OFFICIAL NOTICE OF DECISION

CITY OF ALBUQUERQUE
PLANNING DEPARTMENT
DEVELOPMENT REVIEW BOARD

1. Project # 1002250

FILE: Project # 1002250

**Site Development Plan for Subdivision:
Required Information for Tract A-2, 5.0 acres**

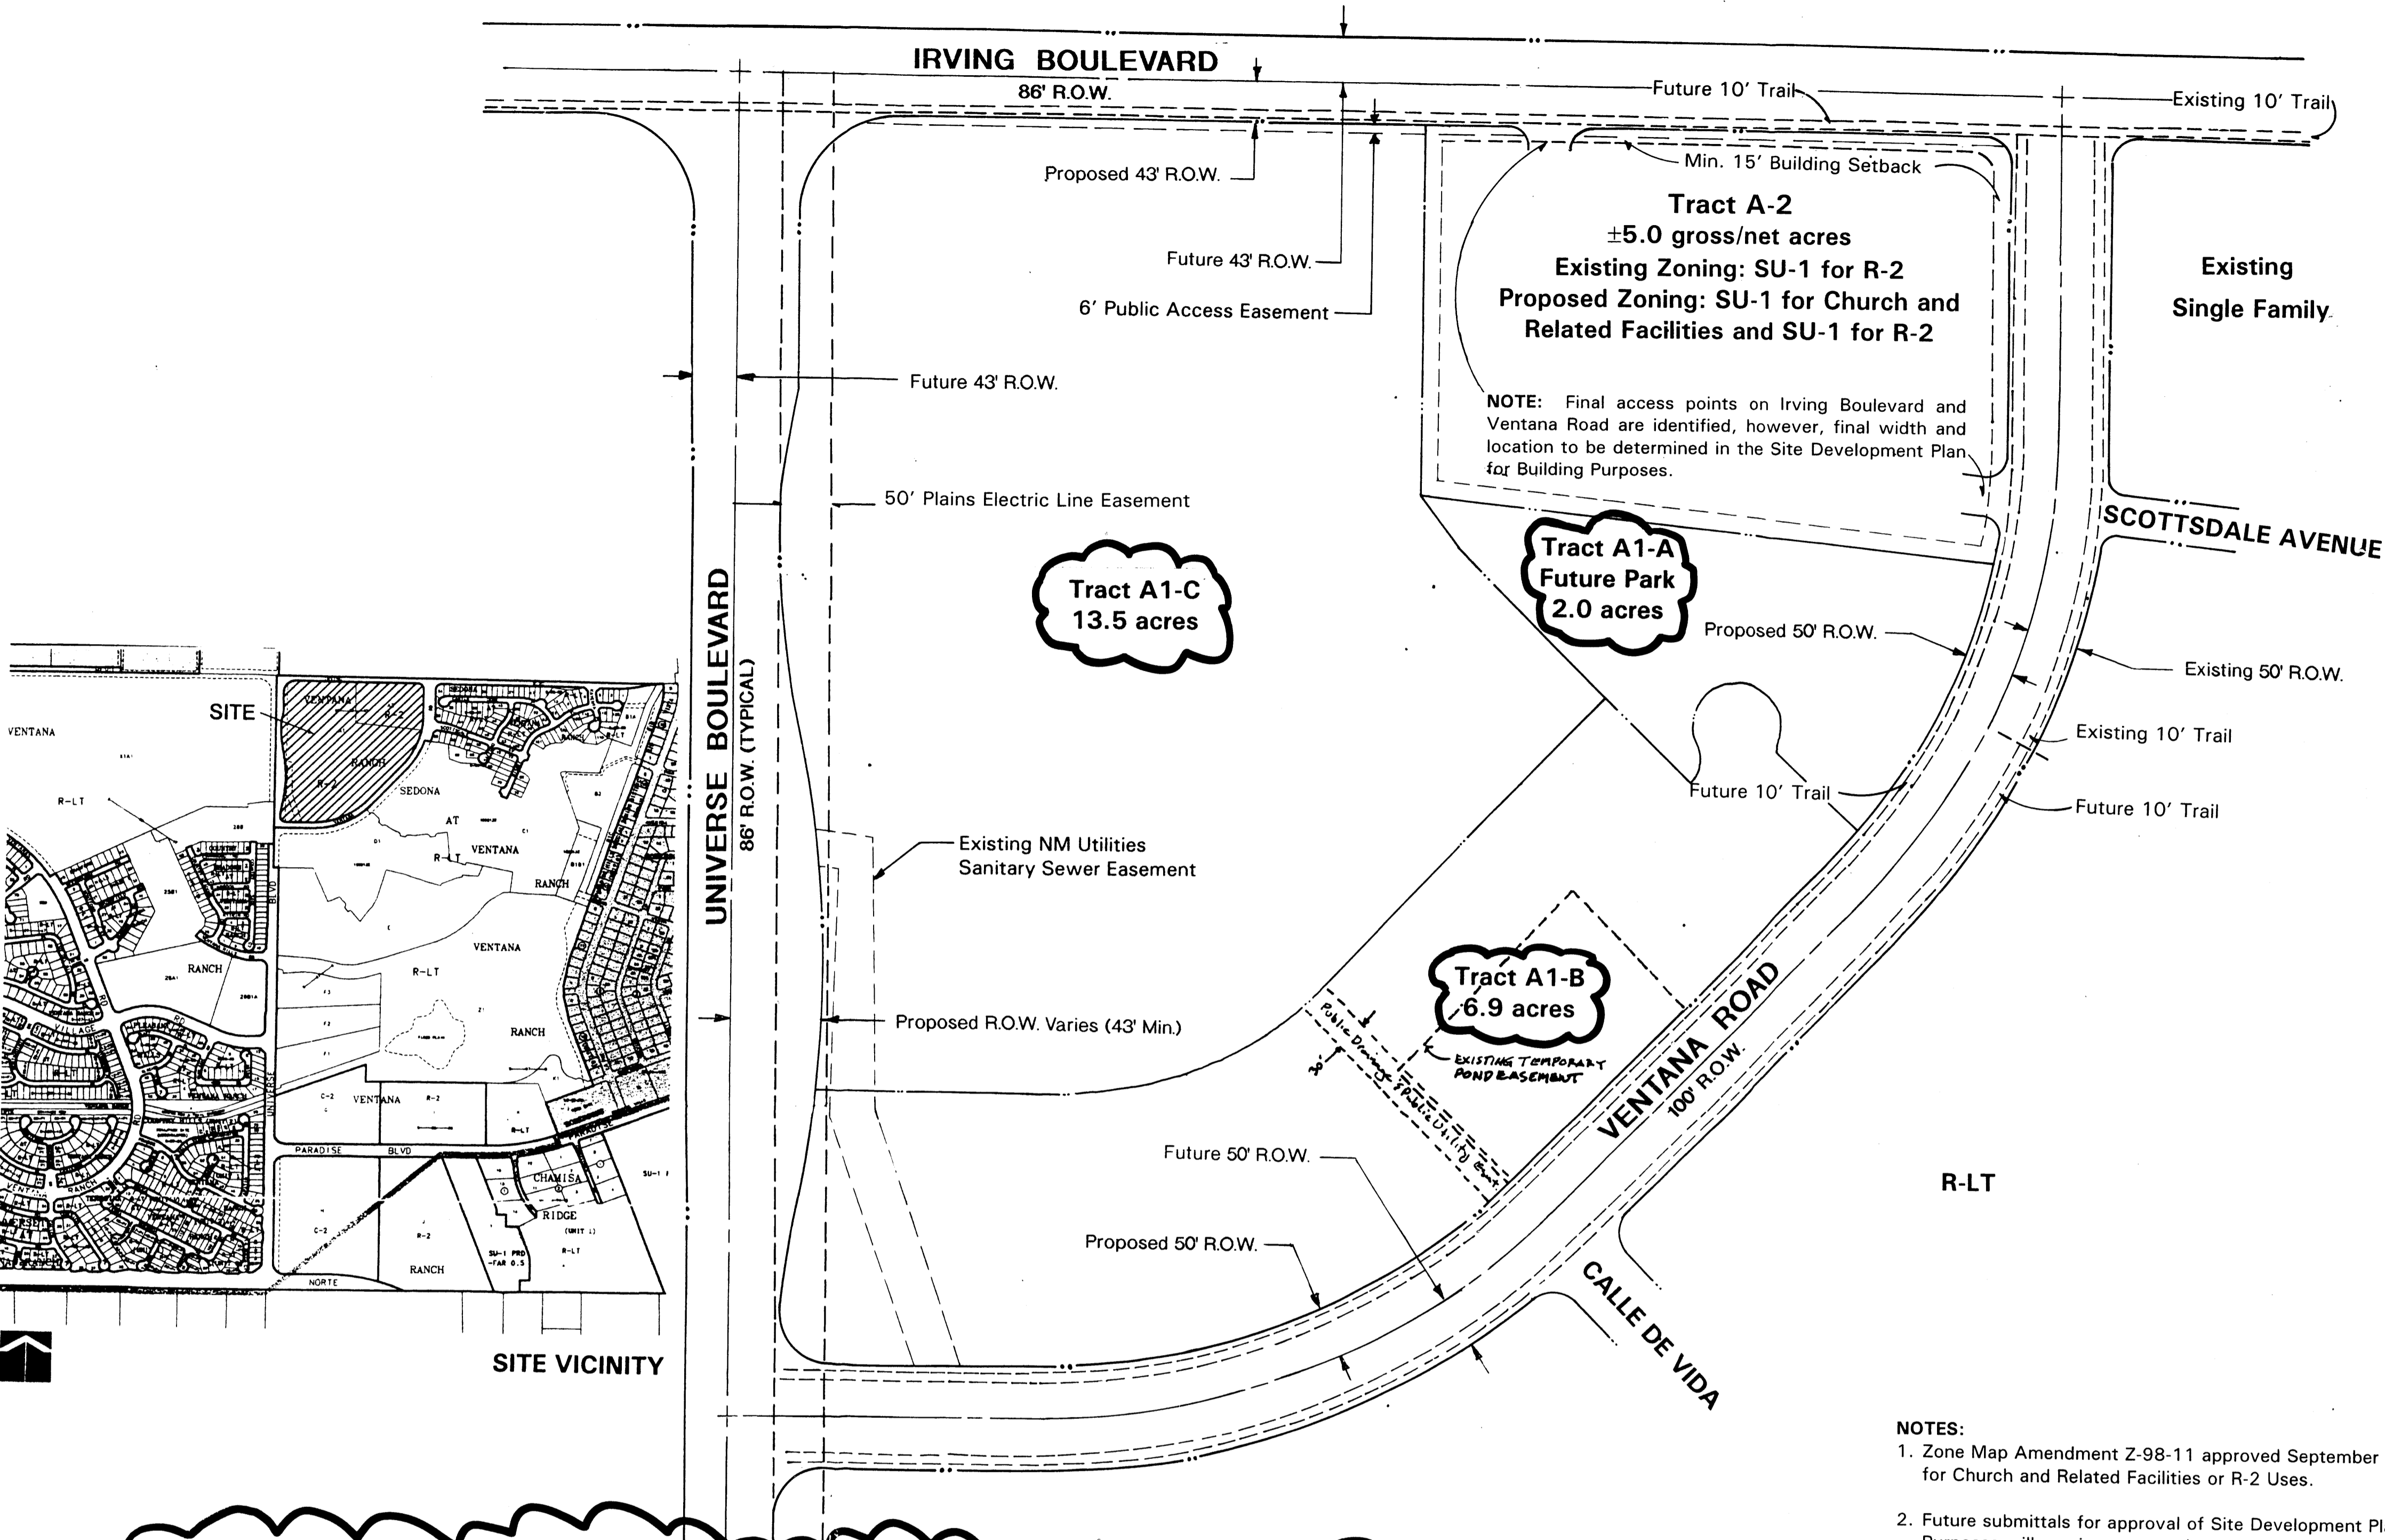
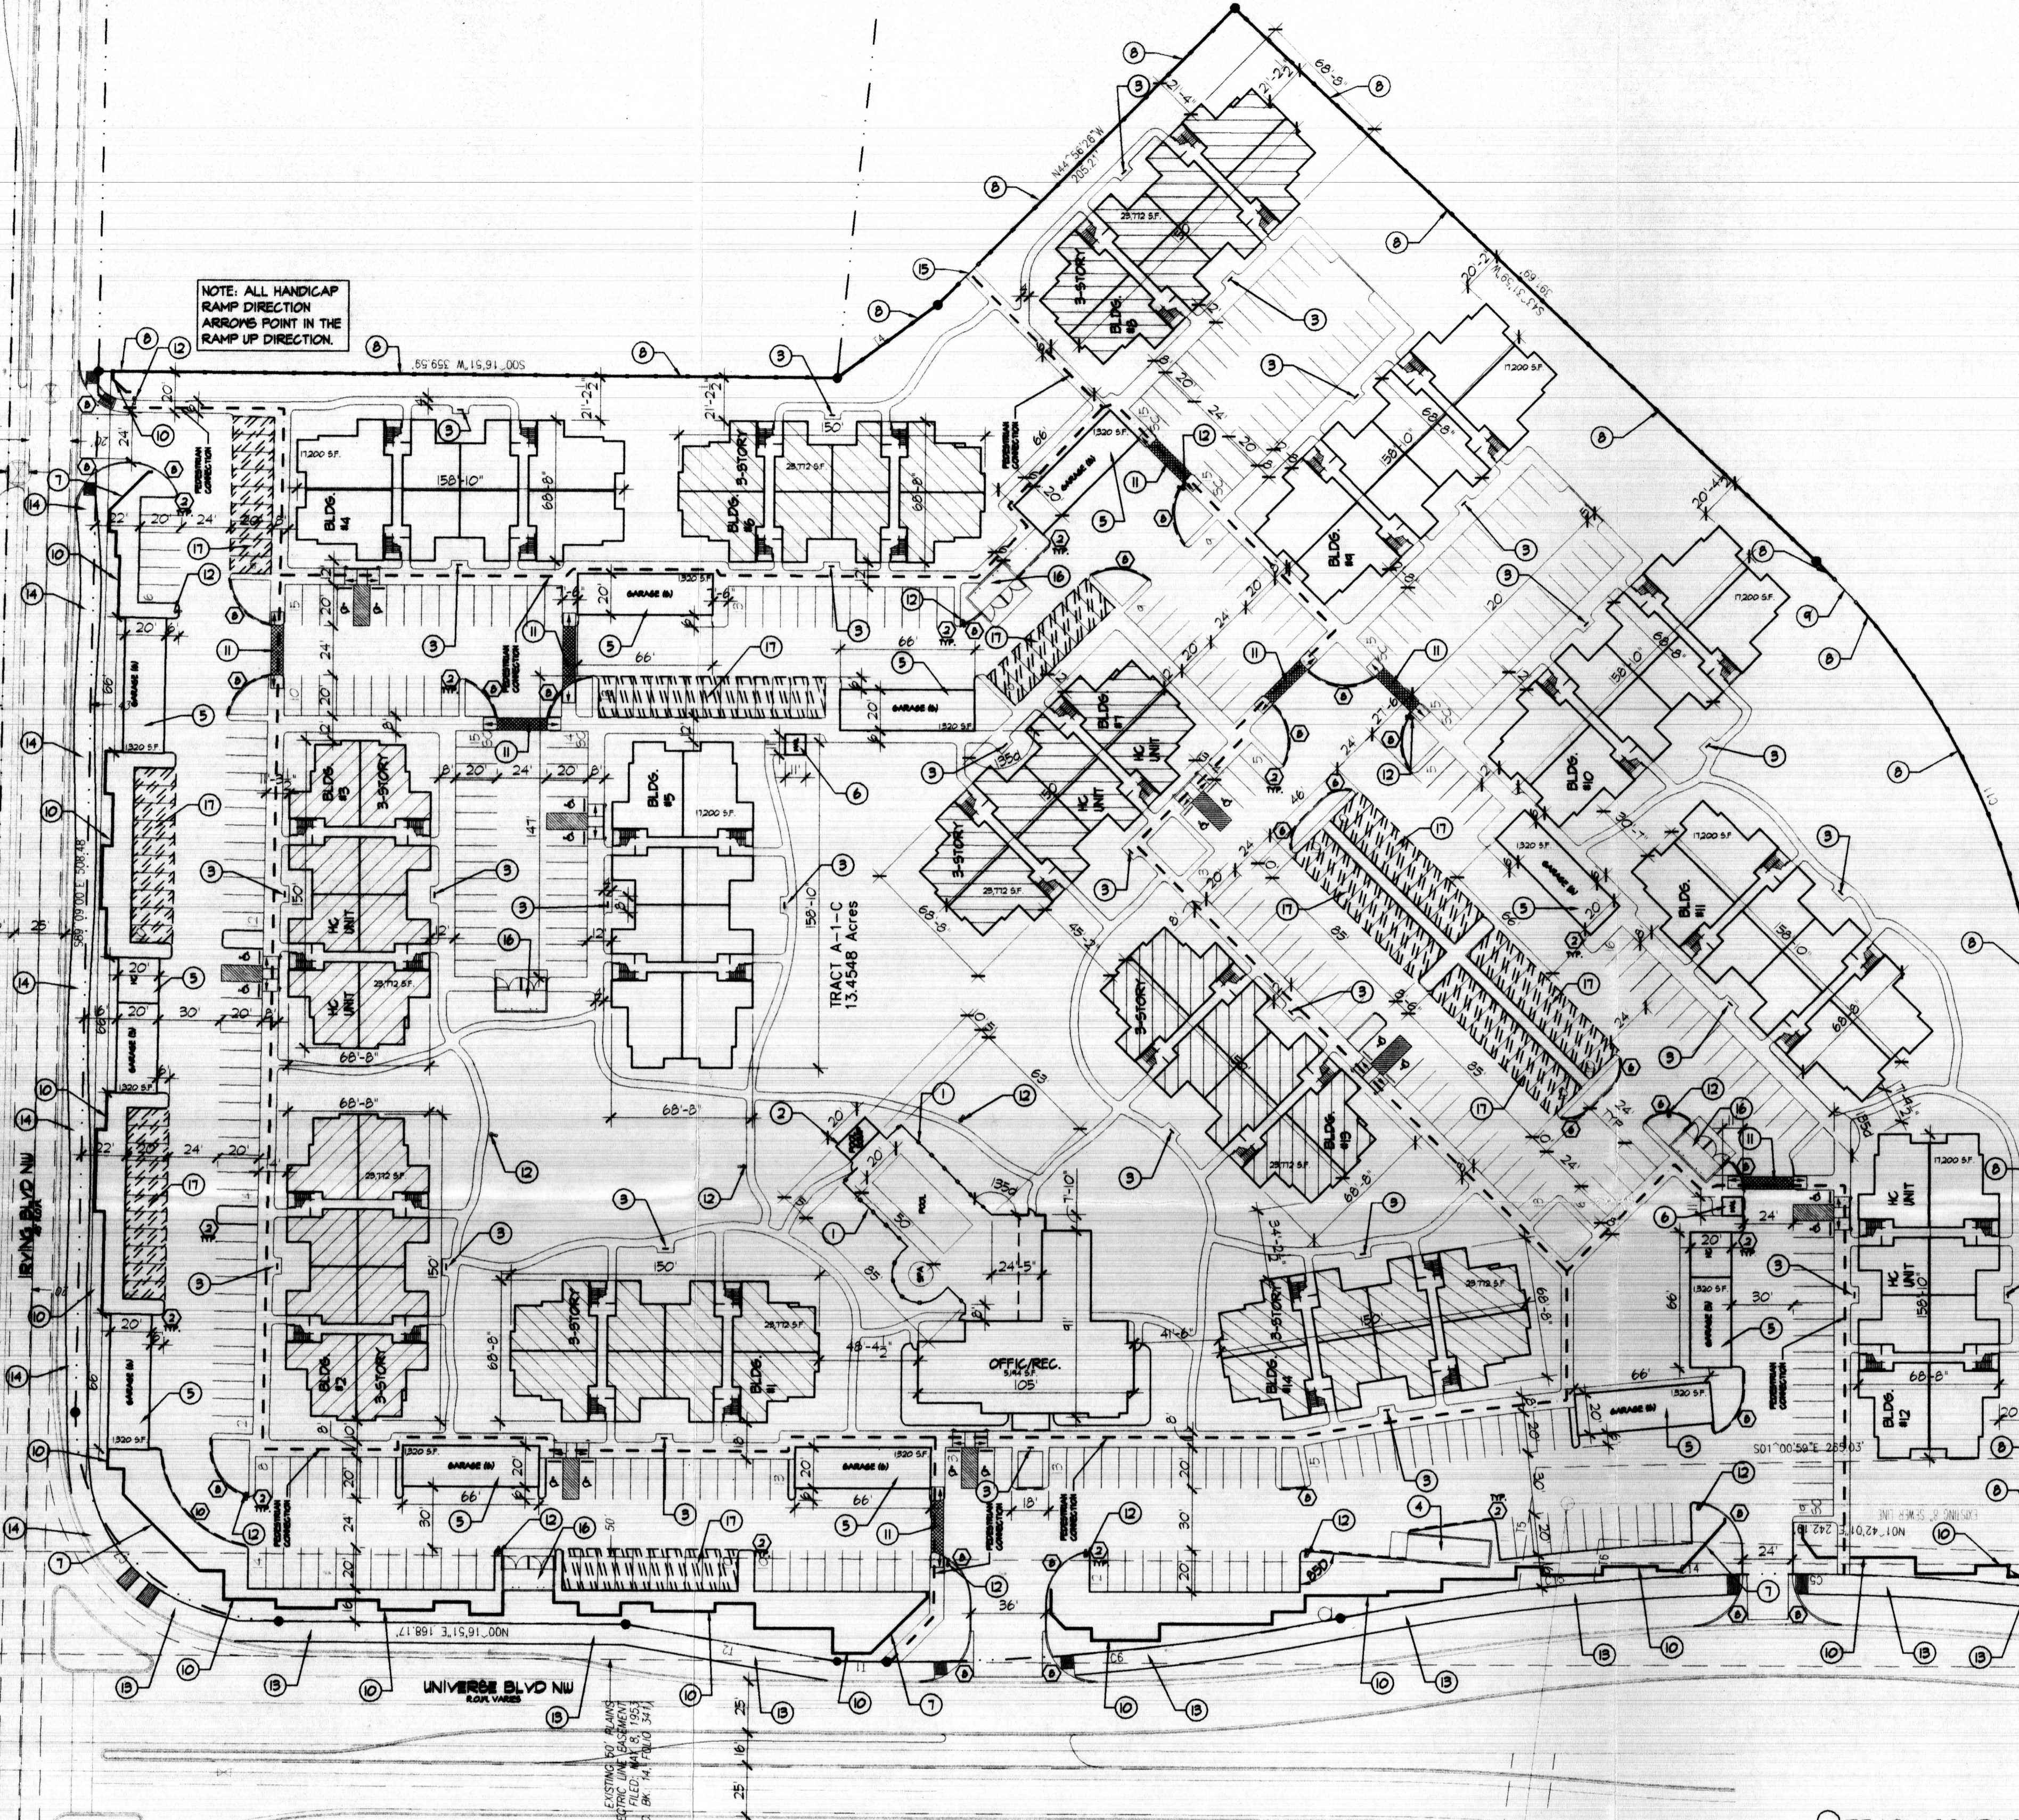
- e. Existing and proposed public utility easements across Tract A1B appear to conflict with proposed single family land use. Application should include a sketch plat consistent with these easements. Otherwise alternate alignments should be proposed. The A1A / A1B lot line warrants explanation. Land is within the New Mexico Utilities Inc. franchise area. Water, sanitary sewer and fire protection services will depend on their system capabilities. An availability statement from New Mexico Utilities Inc. will be required. Any required infrastructure must be designed to City of Albuquerque standards, including water and/or sanitary sewer lines owned and operated by NMUI. Fire protection Requirements including instantaneous flow and hydrant placement must be verified with the Fire Marshals Office and Utility Development prior to site plan sign off at DRB.

job title **VENTANA RANCH APTS.**
 ALBUQUERQUE, NEW MEXICO

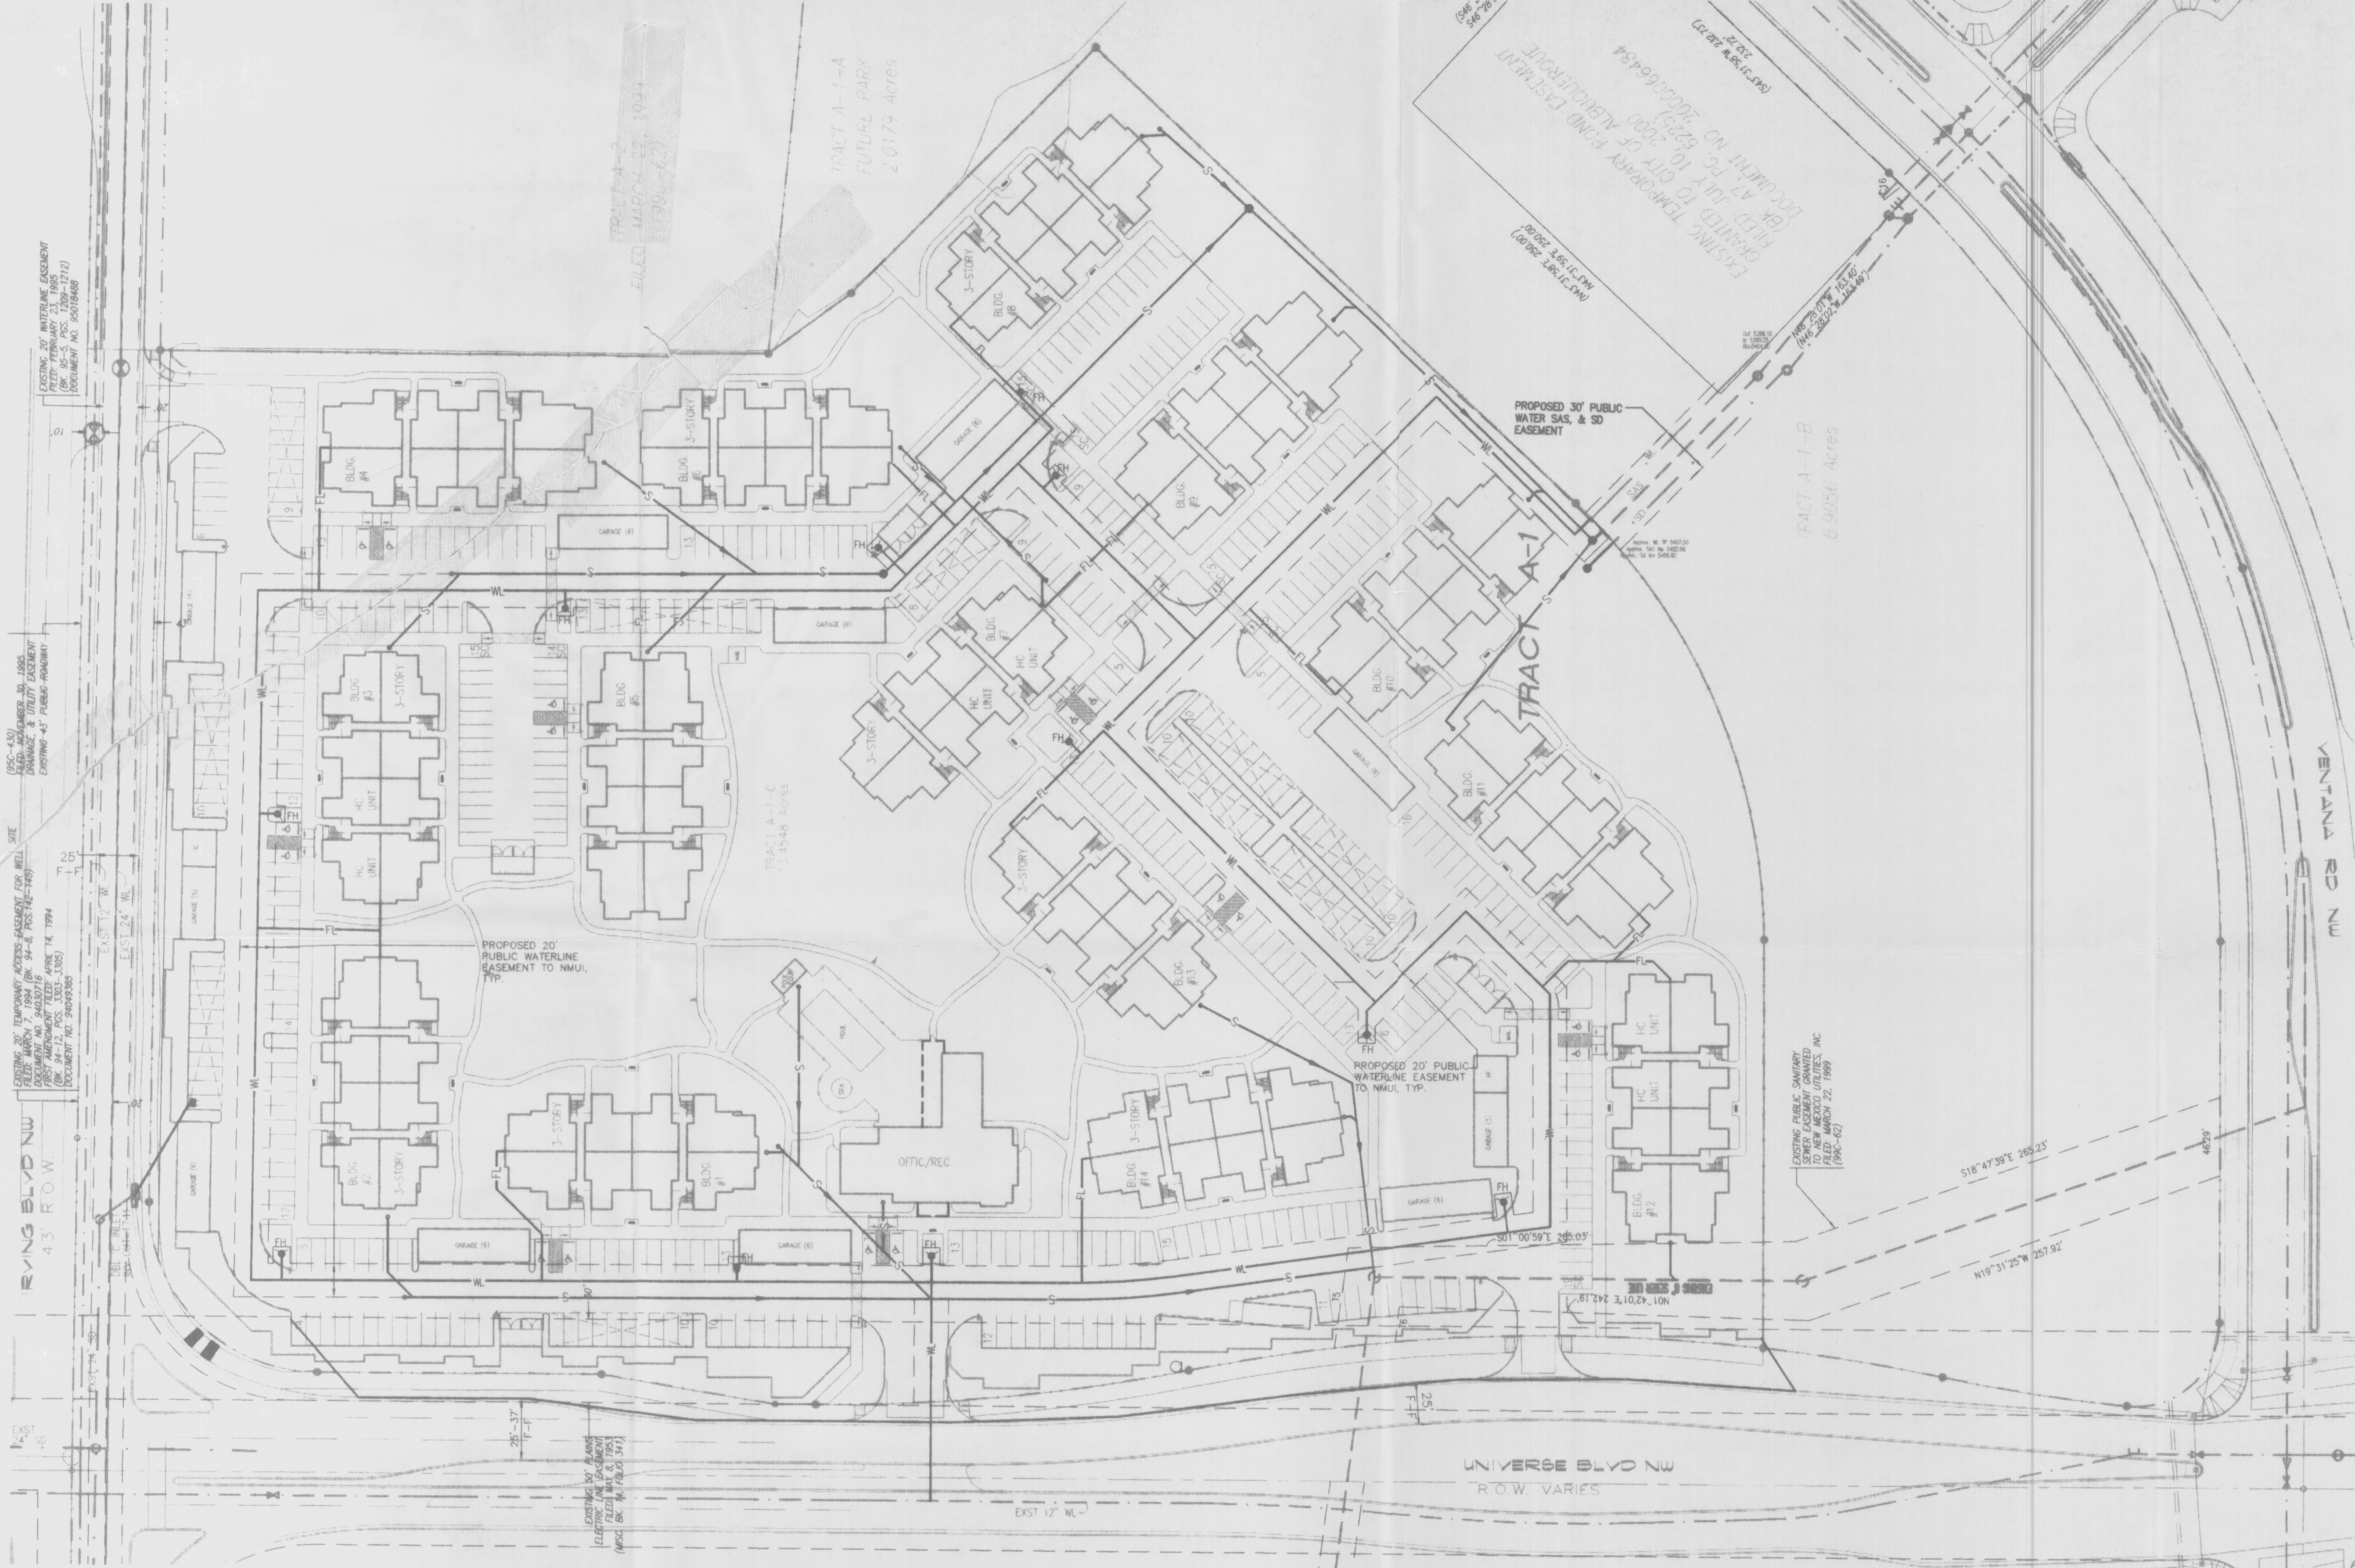
- h. Dedication of an additional 6 feet of right-of-way or acceptable alternative along Irving Boulevard as required by the City Engineer to provide for on-street bicycle lanes.

3. The applicant shall replace the proposed 6' sidewalk on Irving Boulevard with a 10' trail on Irving to connect with the existing trail section.
